**Catchment Management
Authority**
Hunter-Central Rivers

**Subject: Newcastle Coal Infrastructure Group (NCIG) Coal Export Terminal
(MP06_0009) Proposed Rail Flyover Modification Request No. 2**

Thank you for your letter received on the 13 July 2012. The CMA has reviewed the information that you have provided in relation to the proposed Rail Flyover Modification (RFM) and provides the following comments.

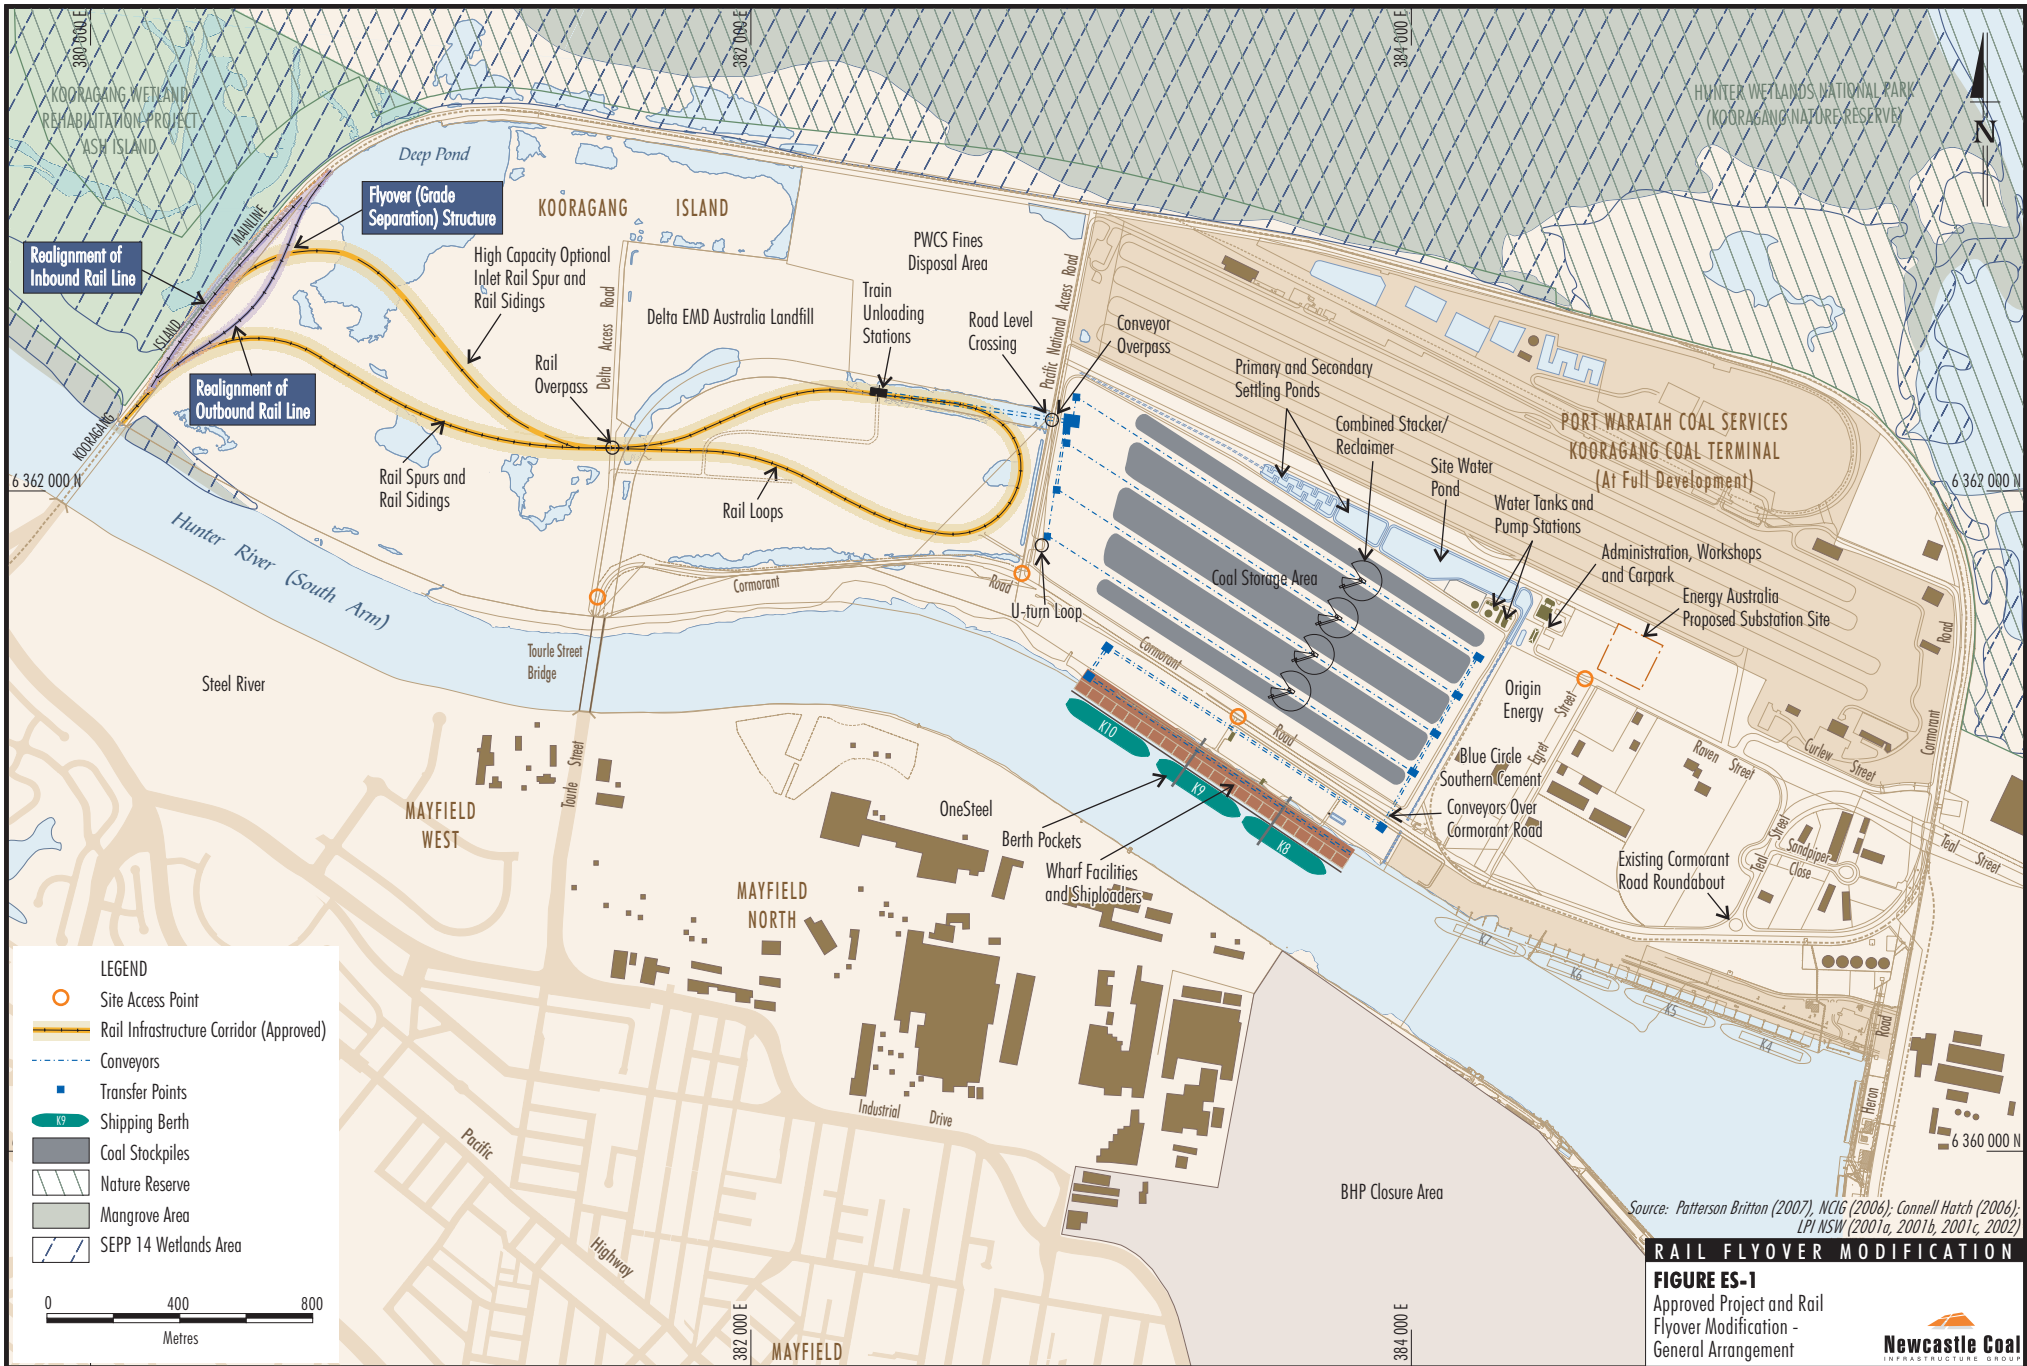
The CMA has concerns regarding the impacts of the proposed RFM in its current form on 'Swan Pond', an important migratory bird habitat adjacent to the proposed works and must object to the proposal.

The CMA is of the view that the Environmental Assessment (EA) documentation provided by NCIG is inadequate in terms of the information provided on migratory bird species and the potential impact that the proposed RFM will have on migratory bird habitat at Swan Pond. Given the importance placed on Swan Pond by the bird watching community it is concerning that the level of assessment provided in the EA is so limited and referred to only as 'additional land to the west'.

In addition, the CMA is concerned at the cumulative impact of the expansion and modification of industrial projects into areas of salt marsh Endangered Ecological Communities (EECs), mud flats, mangrove areas and other key habitats within the lower Hunter estuary. This issue has not been addressed in the EA.
